**ADC Planning Consultation
Response from the Conservation Officer
Additional comments**

Application Number	AW/211/14/PL and AW/215/14/A
Address	Ship Inn Aldwick Street Bognor Regis PO21 3AP
Description	As before
Case Officer	Mr S. Davis

These comments relate to additional plans submitted to the Planning department.

FRONT ELEVATION

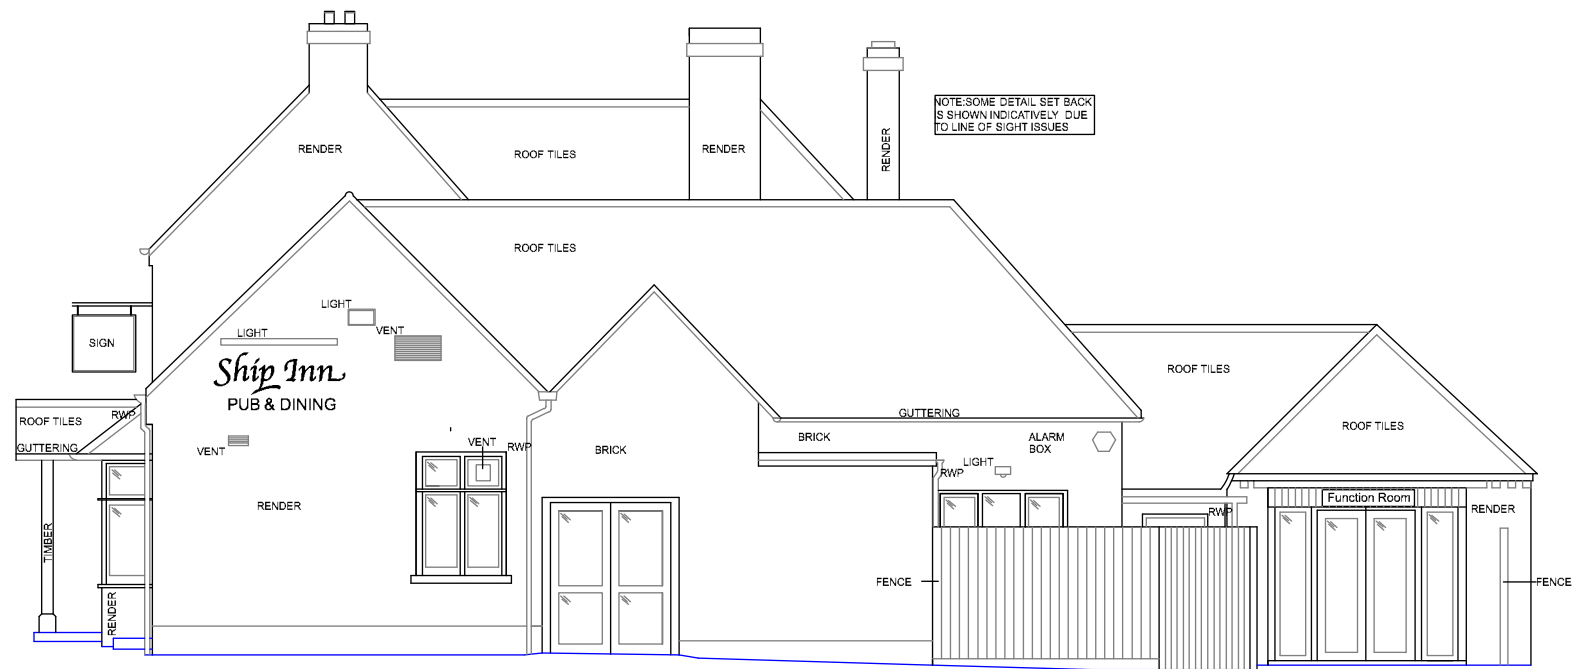
The suggested window detailing to the front elevation is acknowledged. This will tie in with the colour of the windows. Can this be confirmed by condition?

SIDE ELEVATION

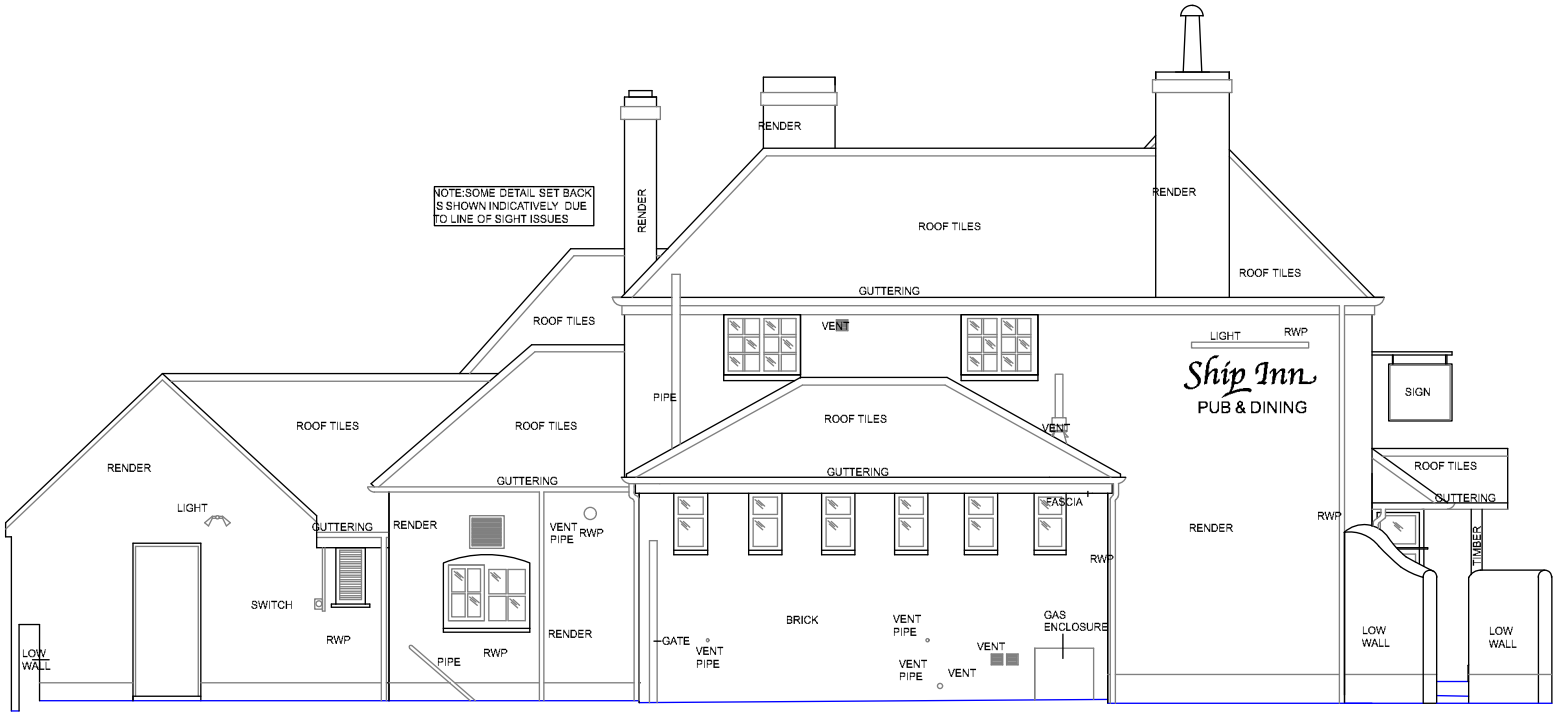
The revised glazing to the eastern elevation is supported, as it limits its impact.

REAR ELEVATION

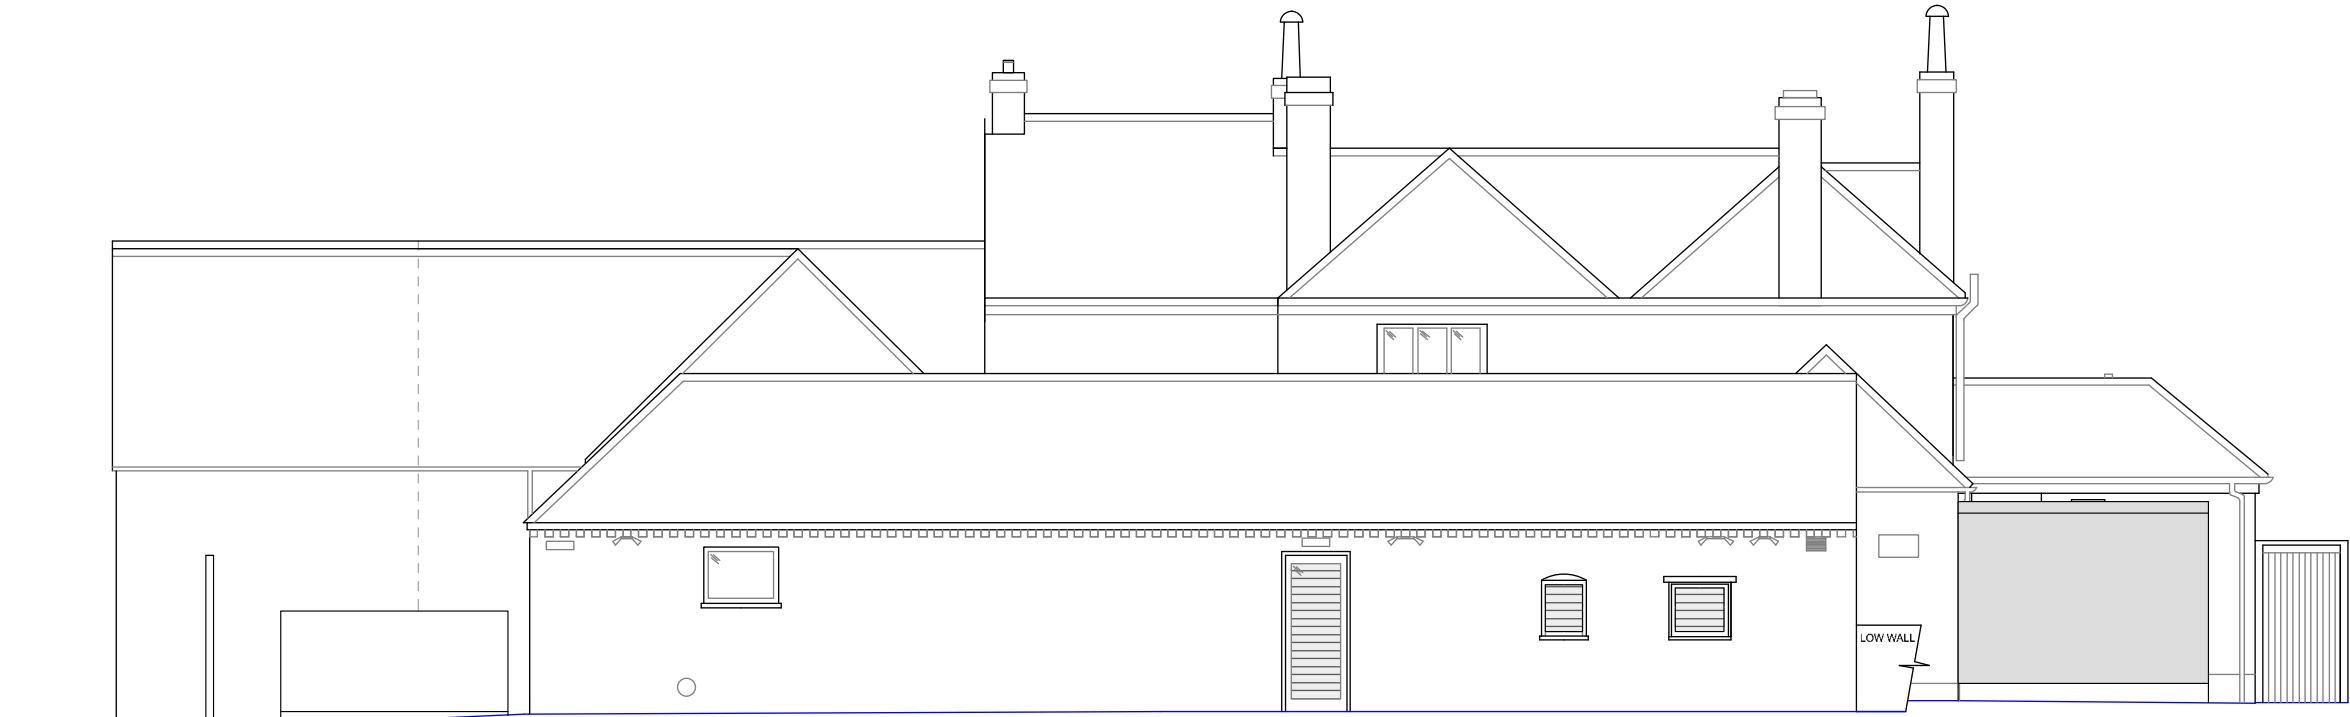
The removal of one of the hanging signs is supported, but I still have strong concerns regarding the design of sign 5. It is still considered that this sign is excessive and should be reduced in size. The majority of the elevation will be hidden from view until relatively close to the building; this will limit the impact that such a sign will have on the passing public.
